From: planning
Subject: Consultation on planning application 3/2014/0438 land east of Chipping Lane, Longridge

From: Fiona Pudge [<mailto:Fiona.Pudge@sportengland.org>]
Sent: 24 June 2014 14:36
To: Daniela Ripa
Subject: RE: Consultation on planning application 3/2014/0438 land east of Chipping Lane, Longridge

Boundary Treatment A:
1800mm high boundary wall with timber fence; 550mm wall

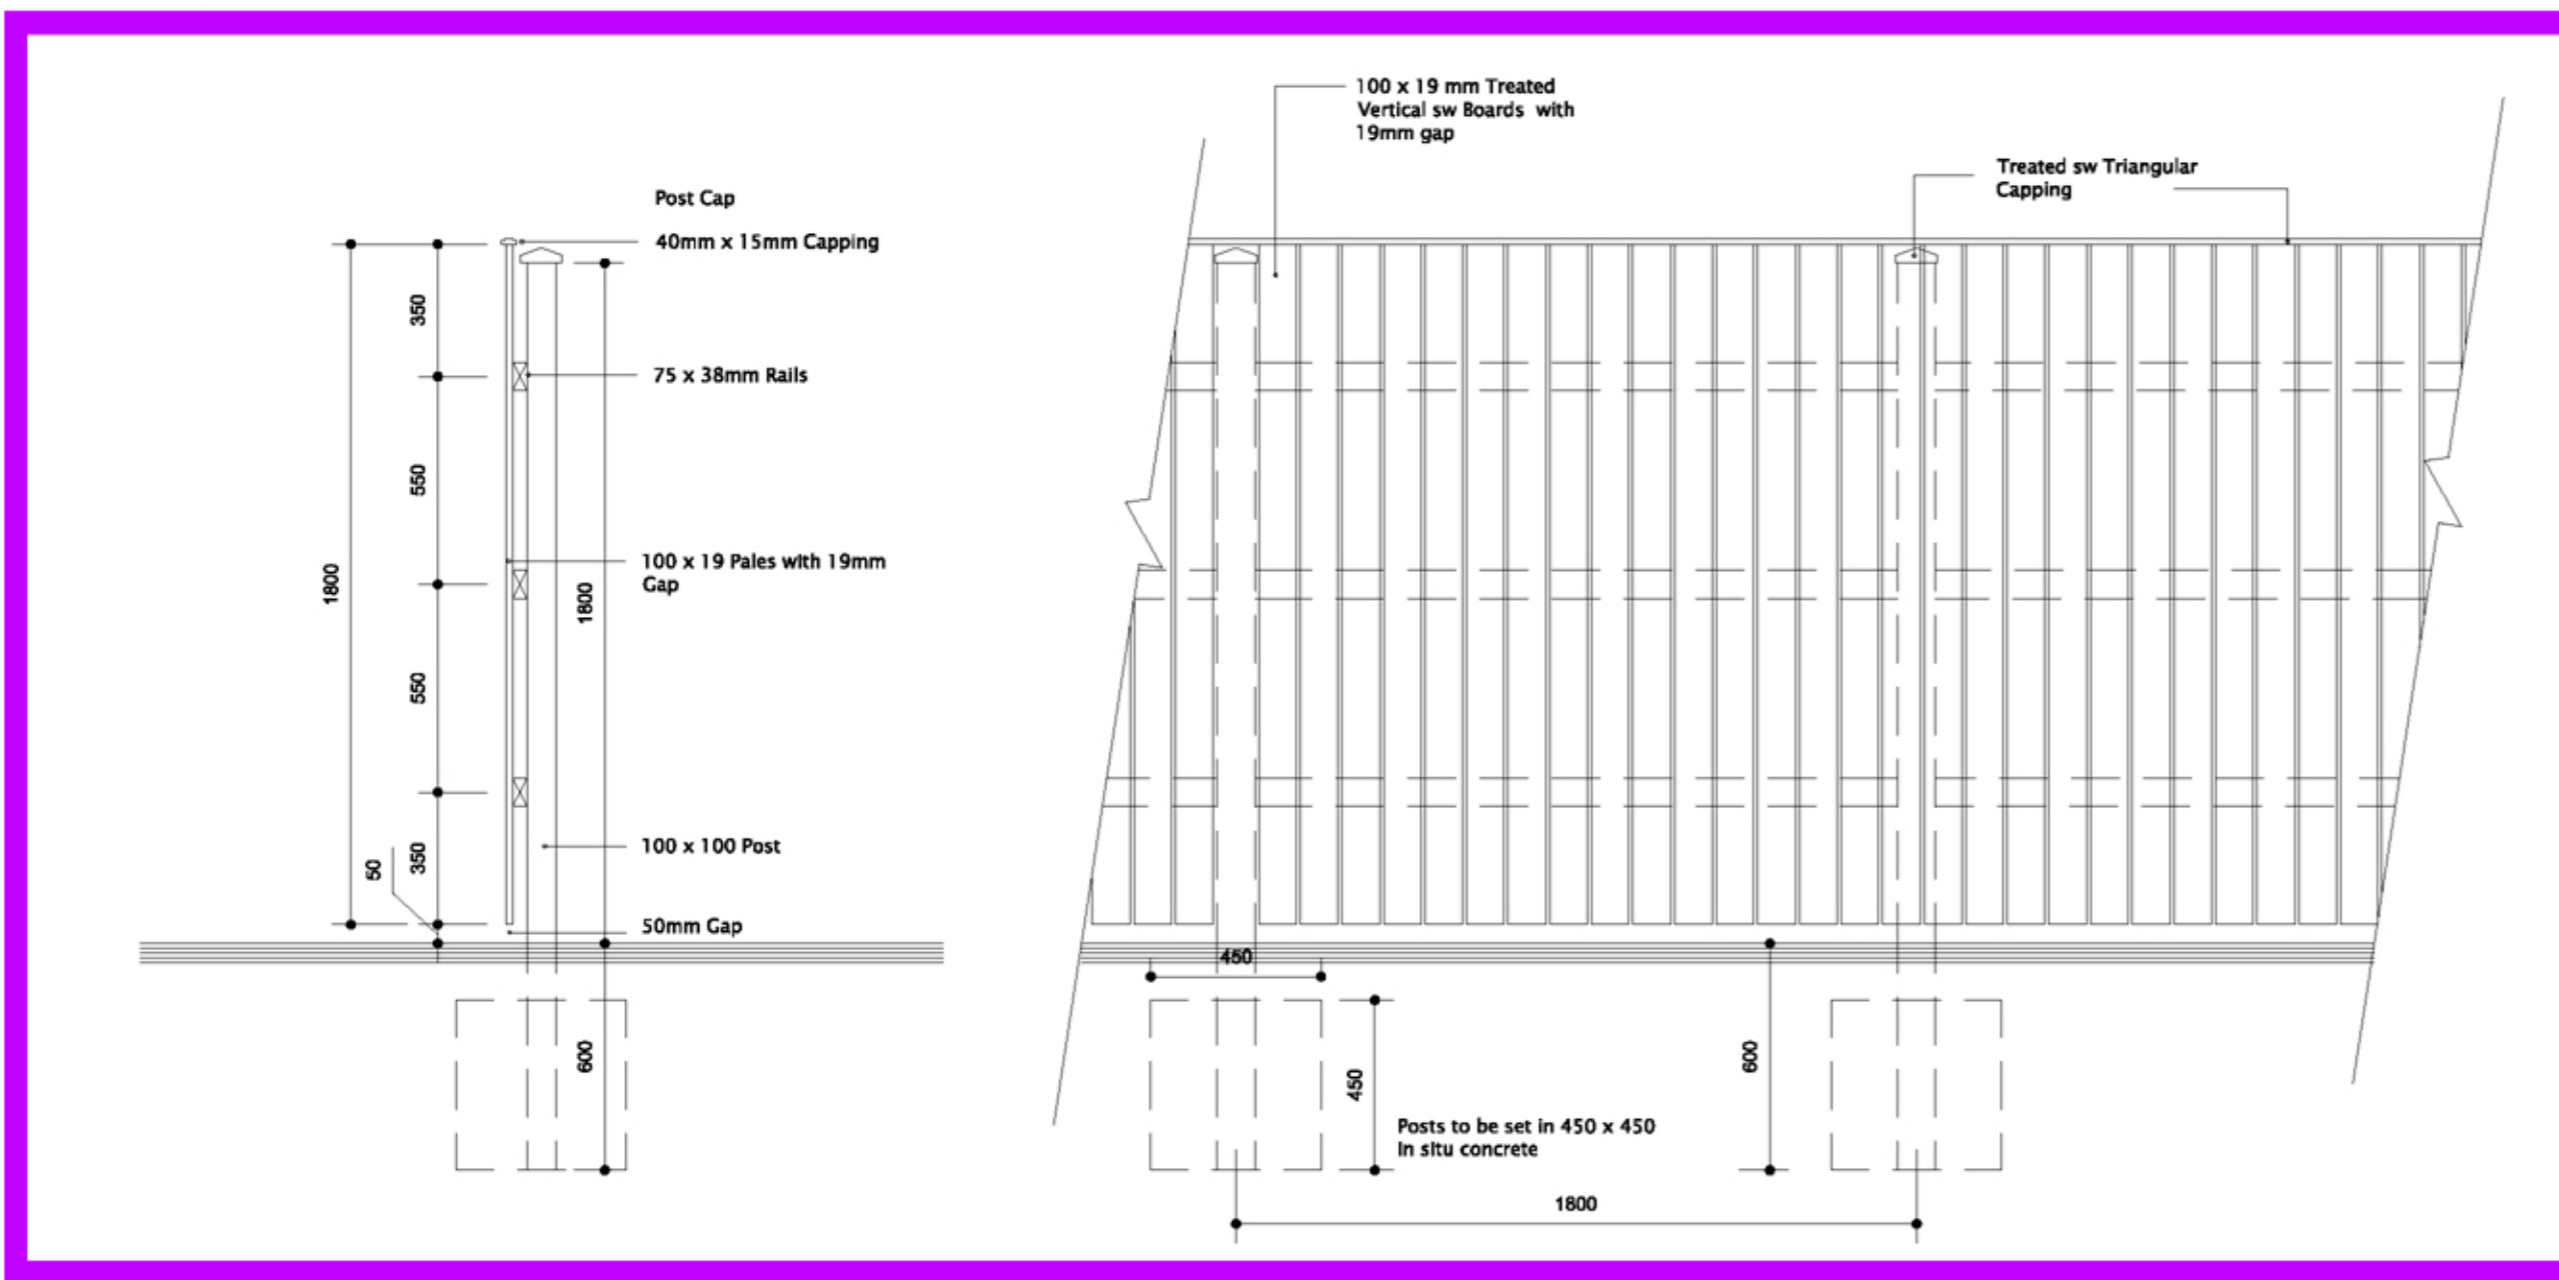
1. *Yes, building housing adjacent to the ground without creating protection from ball strikes would potentially jeopardise the use of the ground. Once the property is constructed the club would be liable for damage to persons or property under civil law (Miller vs Jackson 1977 is the precedent case law) and therefore the cost of using the ground could be uneconomic if a number of civil suits were pursued. In recent times a number of legal challenges have been made against grounds with close proximity to housing including injunctions being sought to prevent play. Without adequate protection we would request you seek a statutory objection. Furthermore it should be noted that 9m on the East edge of the ground is likely to be inadequate due to the length of the boundary. Typically at this distance (circa 40m from the square) a fence of 12m in height would be expected but this should be subject to a detailed risk assessment and design.*

2. *Whilst telescopic netting is technically possible it is not practicable over such a large area without very high cost for both construction and maintenance. The imposition of the maintenance costs of this on the cricket club would be unreasonable.*

My conclusion is that a risk assessment to determine the level of ballstop fencing is required. This could be included as a condition if you are minded to approve the application. If the requirement ballstop fencing is removed then Sport England would have no choice but to lodge a statutory objection because of the prejudicial nature of the development.
